TO:	Helen Donaldson, Senior Planner	DATE:	8/6/2018
FROM:	Michael Guethle, PE; Ryan Wingard, PE	PROJECT NO.:	13982B
SUBJECT:	St. John St. - 222; MMC Parking Garage (PL-000207-2018)

Wright-Pierce has reviewed the Level III Site Plan Application information provided for the Employee Parking Garage redevelopment proposed at 222 St. John Street, including the response to initial reviewer comments. The project will include redeveloping an existing parking lot into a nine-level parking garage with approximately 2,400 parking spaces; redeveloping another existing parking surface to provide a pedestrian access and vehicle access to levels 1-8 of the building; and redeveloping a third parking surface to provide 52 additional spaces of surface parking. Off-site improvements to St. John Street and D Street are also included in the proposed work. The work will reduce the total impervious surface area on the property.

CIVIL DETAILS - 3

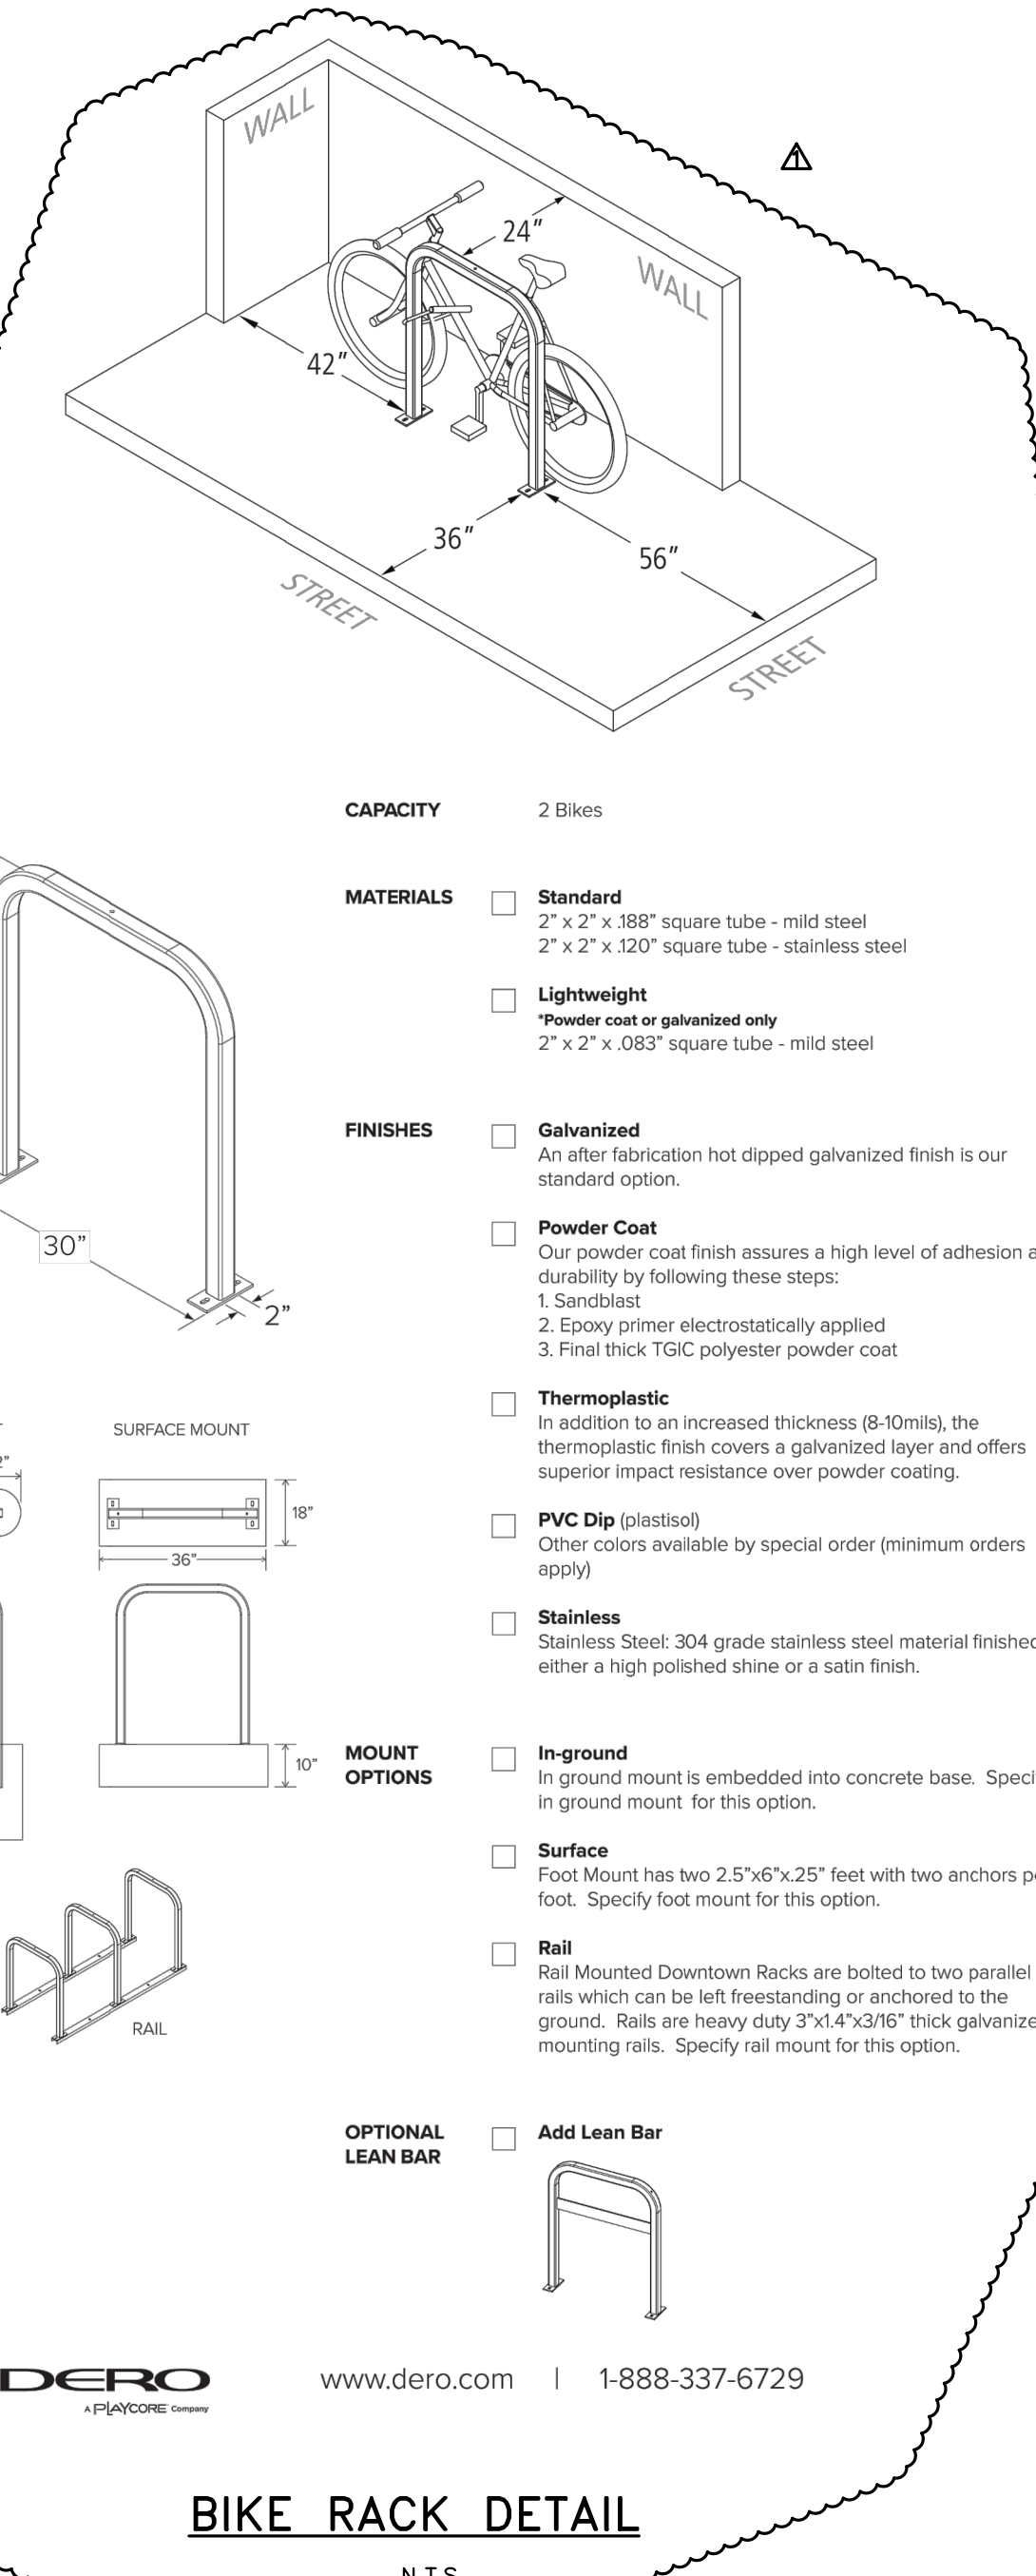
- a. The applicant has confirmed site grading will not be affected by future information regarding soil management, as that information will only be used by the contractor for their own management.
- b. Grading review identified that Pipe 14 between CB15-CB16 has a negative slope. Please revise or provide explanation.
- c. Top of Curb and Bottom of Curb information at CB-18 appears to be inverted. Please revise or provide explanation.
- d. Much of the proposed storm drain has between 4 feet and 3 feet of cover. Detail on C-202 indicates rigid insulation shall be provided in these locations. No further action necessary.
